Our Ref: AW/313/19/HH

**Town & Country Planning Act 1990 (as amended)
Town & Country Planning (Development Management Procedure) (England) Order 2015
Application for Planning Permission for Works or Extension to a Dwelling**

Development Proposed ground floor extension to the south elevation. Internal alterations.
Roof conversion.
Two new dormers on North and South elevations.

Location Cliveden Beach Close Aldwick

EXISTING SITE PLAN, Sc. 1:500

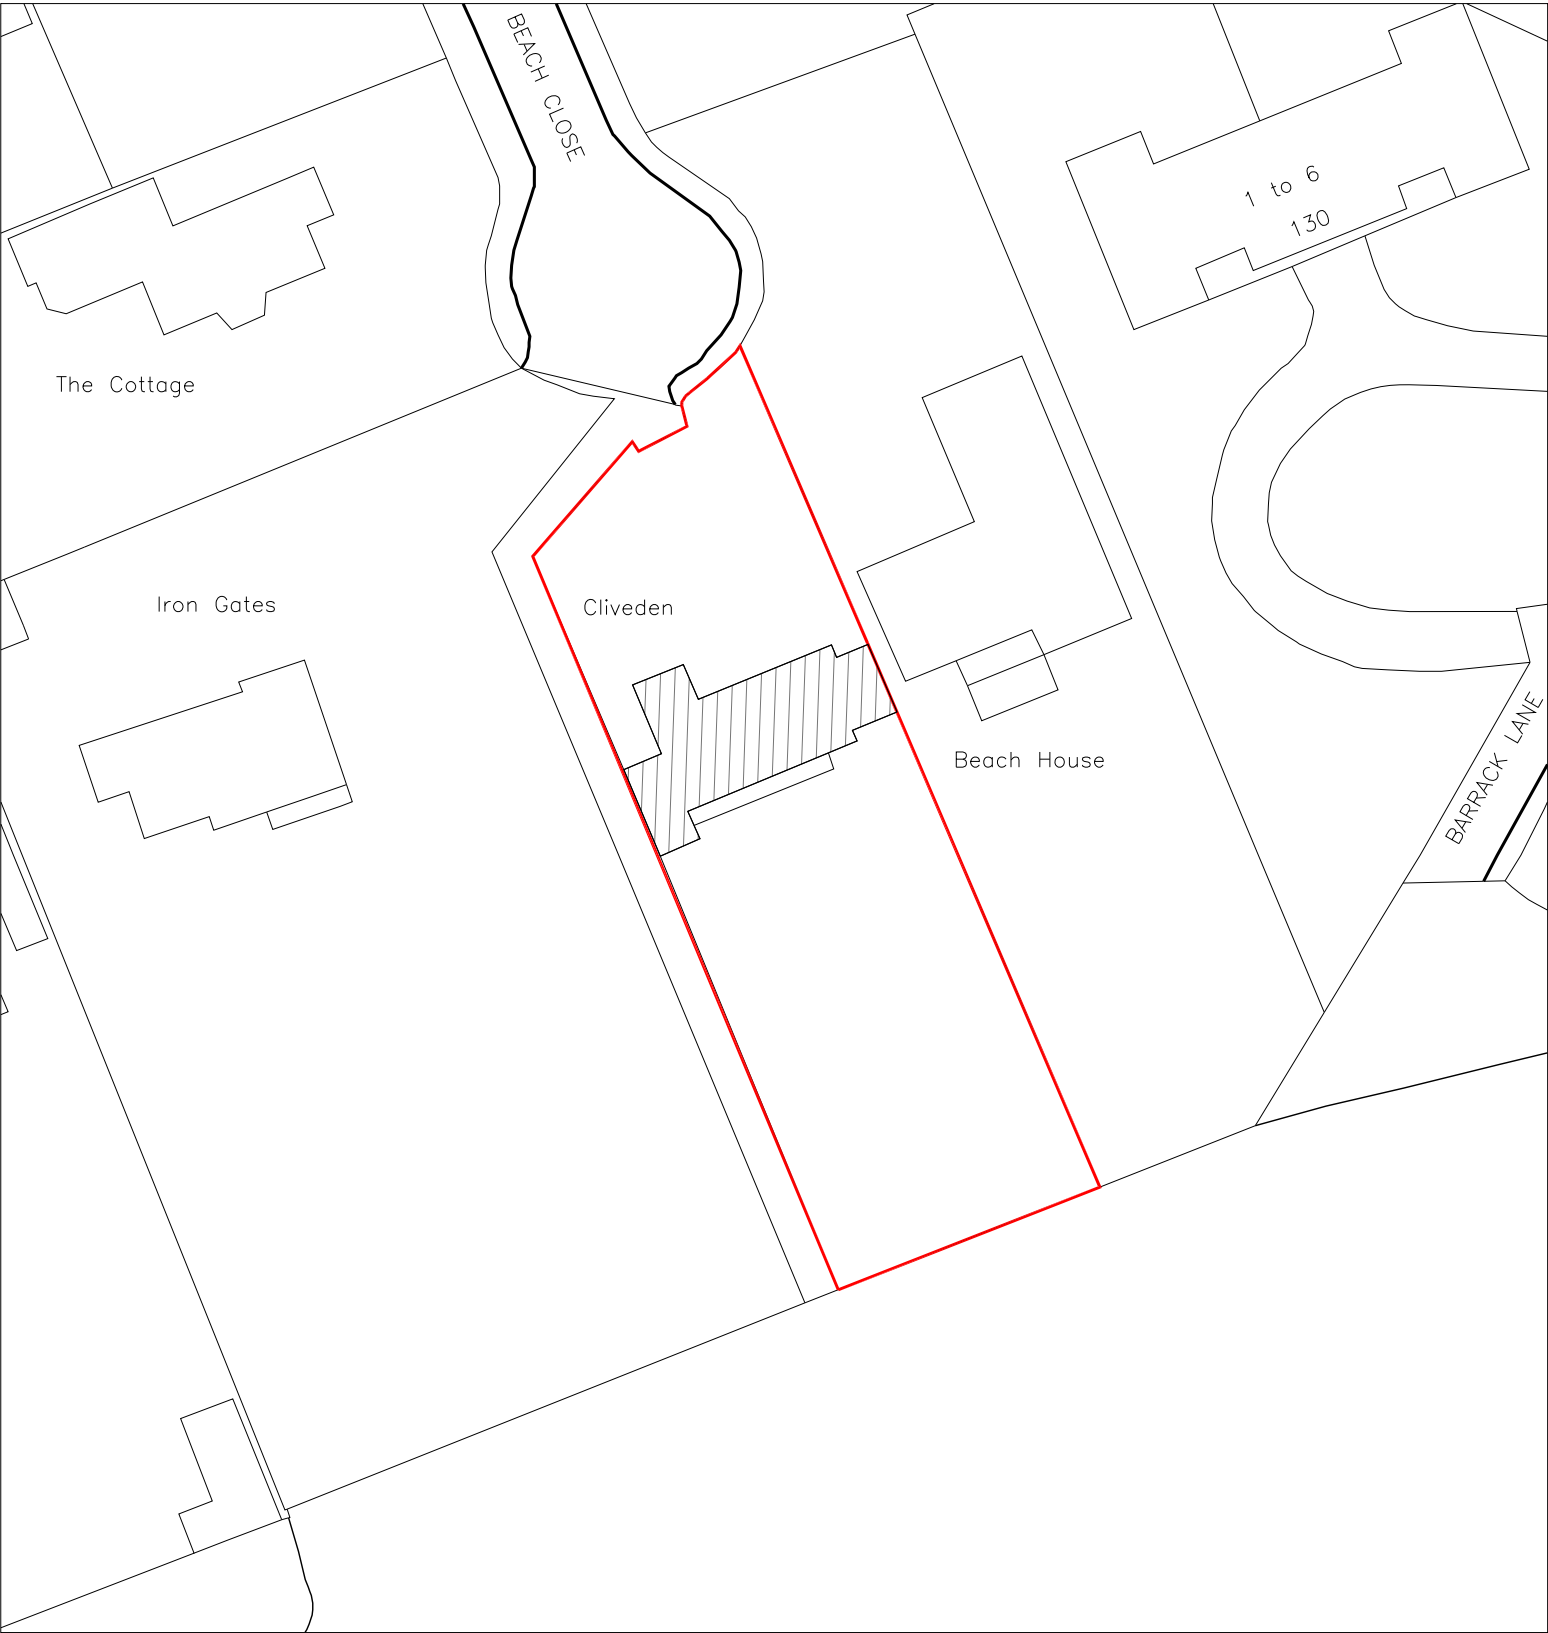
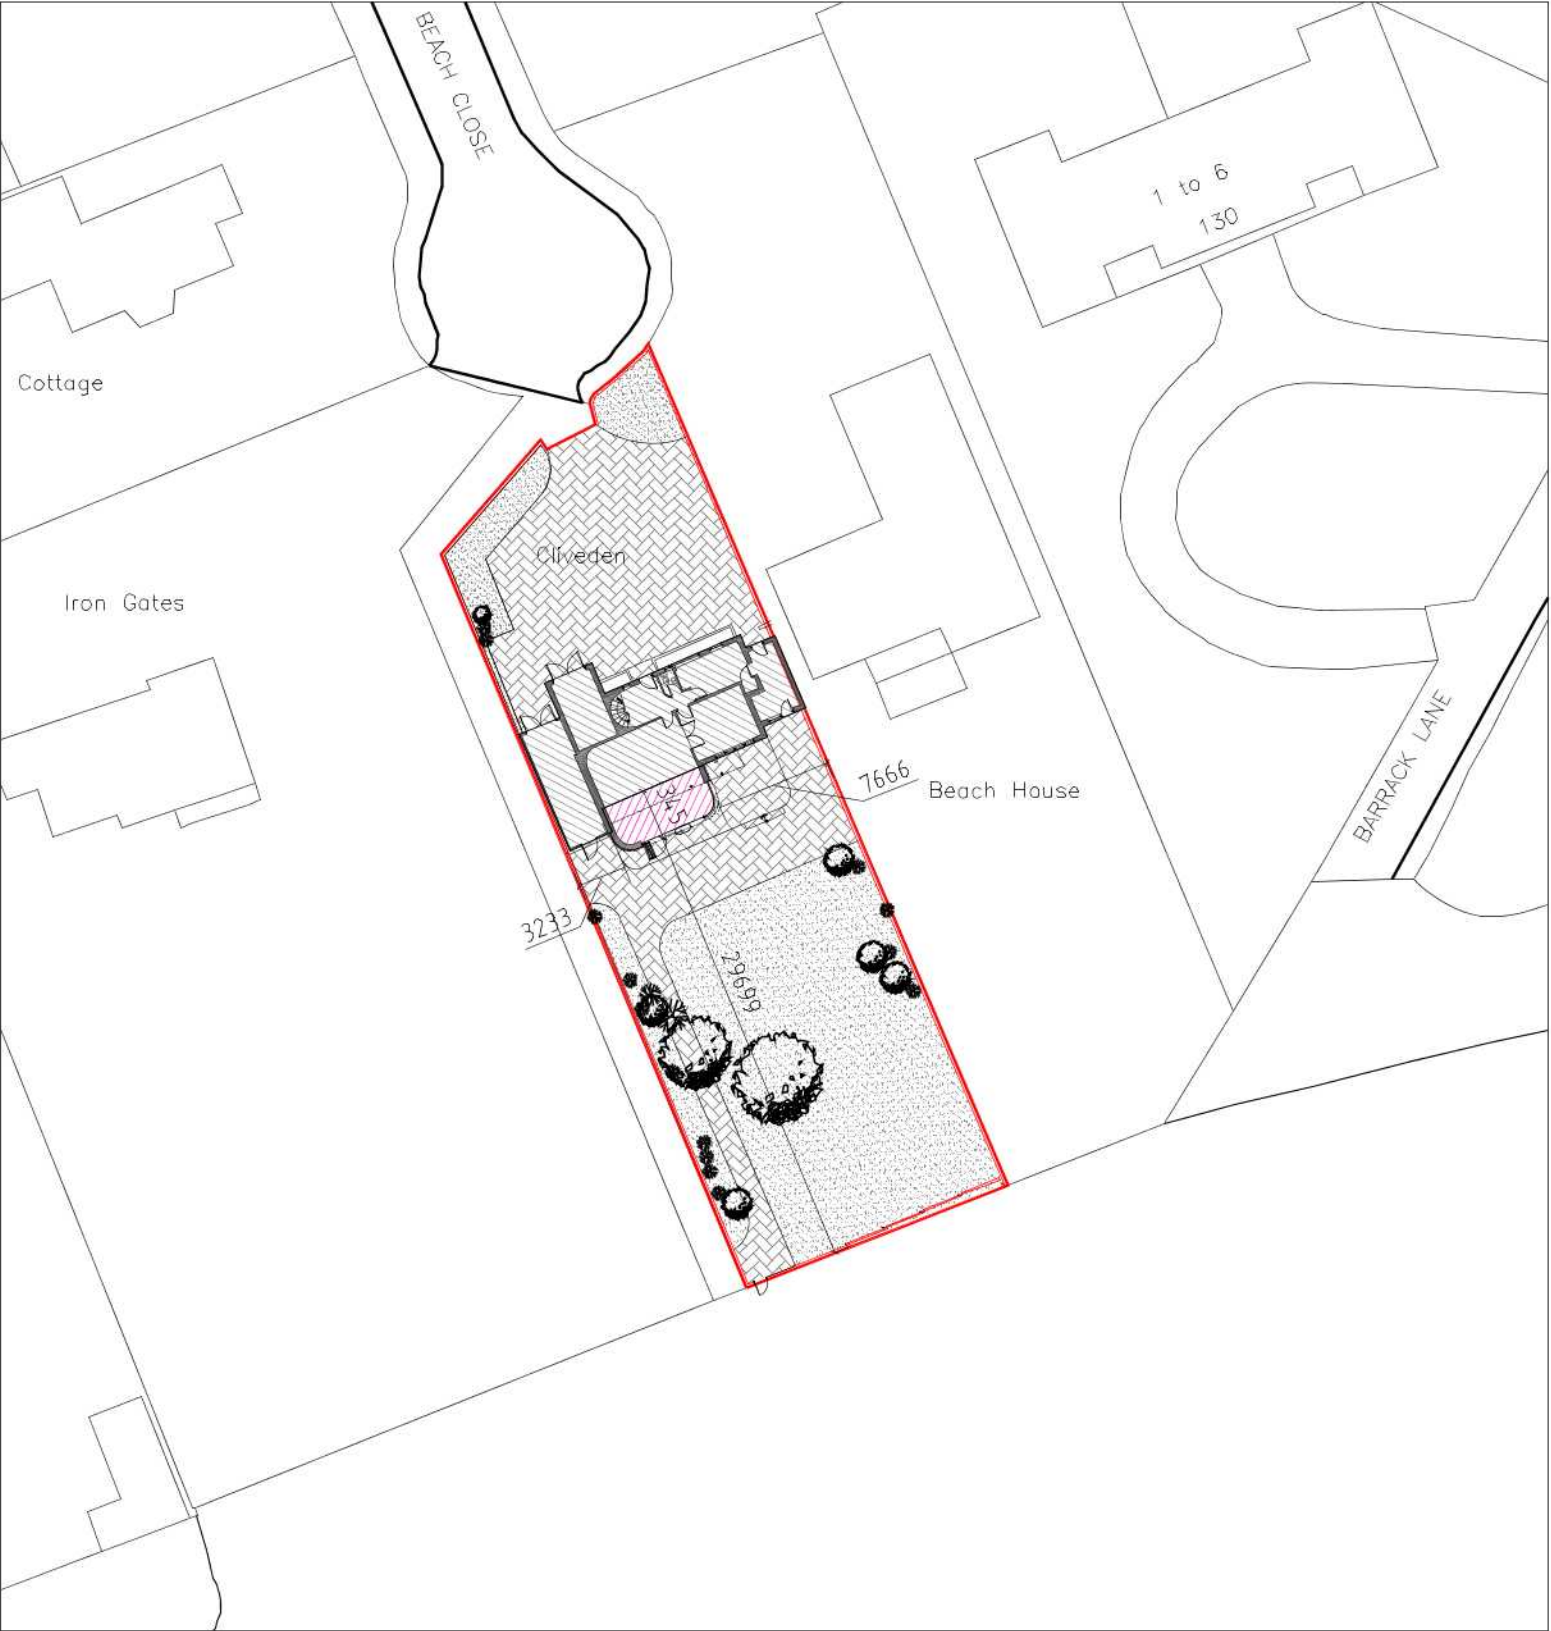
Block Plan

You are required to include dimensions from all proposed extensions to all site boundaries.
